TRANSPORT TECHNICAL NOTE / ADDENDUM

Heathrow Point West, 234 Bath Road, Heathrow, UB3 5AP

Planning Application 41331/APP/2025/3250

Prepared by	Total Planning
Date	6 August 2026
Document reference	TP/HPW/TTN/01
Status	Issue 01 - For submission

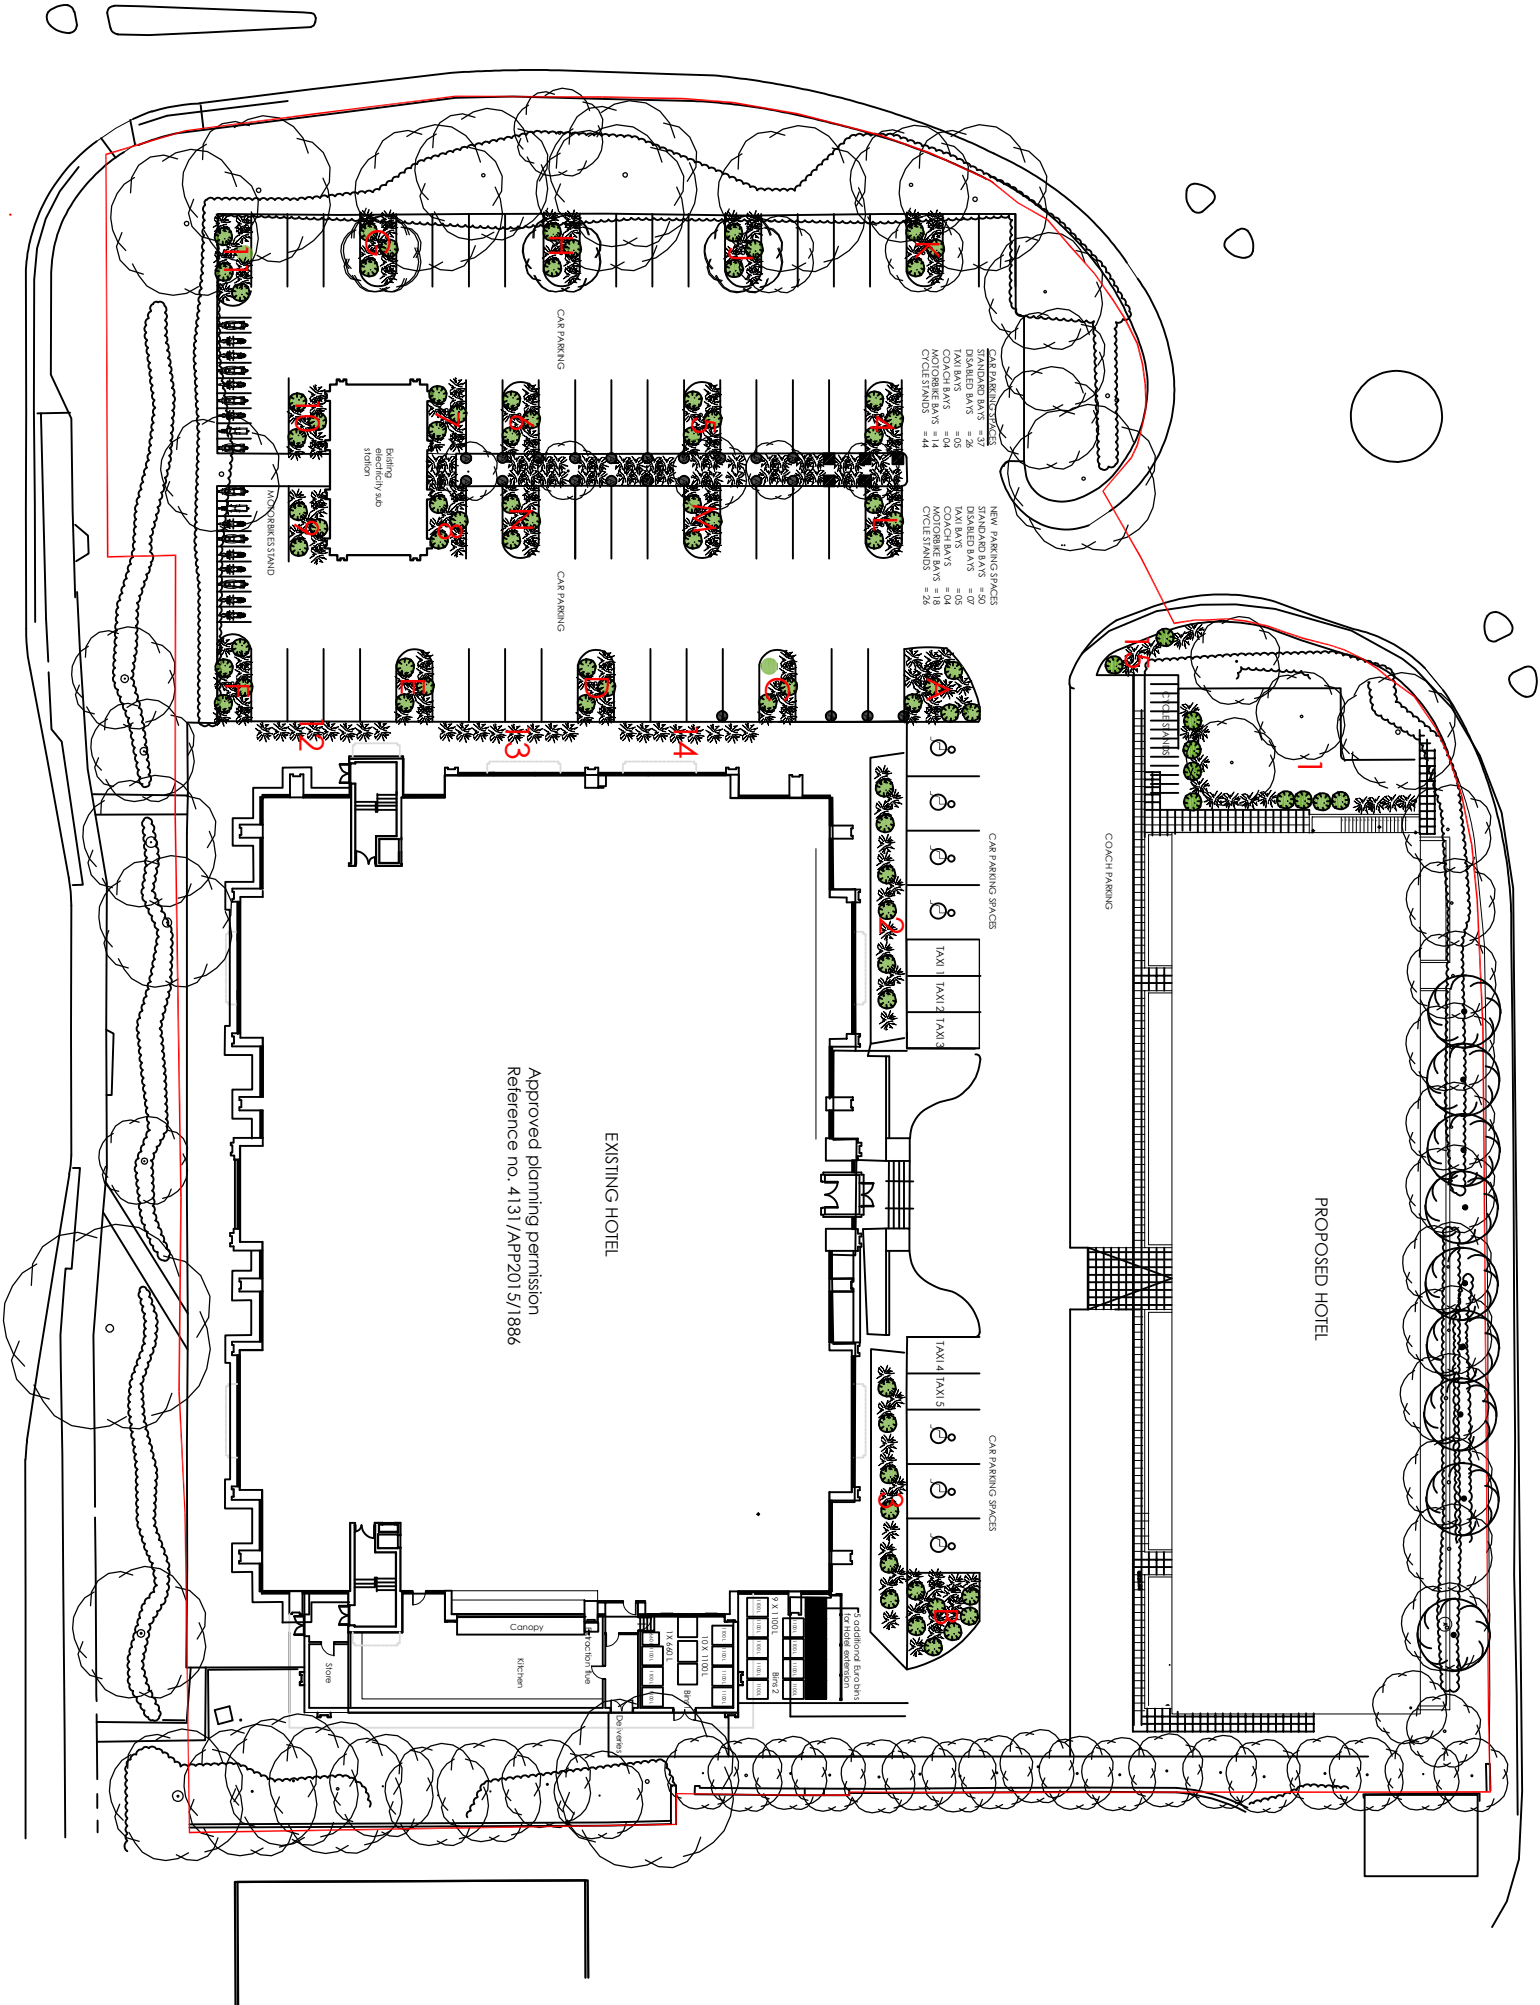
3.1 The intended and proposed provision is two coach bays. These are the two bays identifiable within the hotel forecourt. The reference to four coach spaces on the earlier parking plan is a drafting error; it is not proposed to provide or identify two additional coach spaces. References to three coach bays in the January 2026 transport documents are also superseded.

3.3 The revised parking-plan annotation should therefore state '2 coach bays'. Any plan annotation stating '4 coach parking spaces' is superseded by this note and should be removed from the next drawing issue.

Plan element	Required annotation
Car-parking schedule	TOTAL CAR PARKING: 57 SPACES, COMPRISING 50 STANDARD SPACES AND 7 ACCESSIBLE SPACES
Coach bays	2 COACH BAYS
Cycle stands	26 SHEFFIELD STANDS PROVIDING 52 CYCLE SPACES
Long-stay cycle parking	8 SECURE AND COVERED SHEFFIELD STANDS PROVIDING 16 LONG-STAY CYCLE SPACES
Short-stay cycle parking	3 SHEFFIELD STANDS PROVIDING 6 SHORT-STAY CYCLE SPACES
Additional cycle capacity	15 SHEFFIELD STANDS PROVIDING 30 ADDITIONAL FLEXIBLE CYCLE SPACES
Annotation to delete	Delete any reference to '4 coach parking spaces' or '3 coach bays'.

The following annotations should be incorporated into the next revision of the parking or site-layout plan. Until that revised drawing is issued, this schedule provides the definitive interpretation of the transport provision shown on the submitted plans.
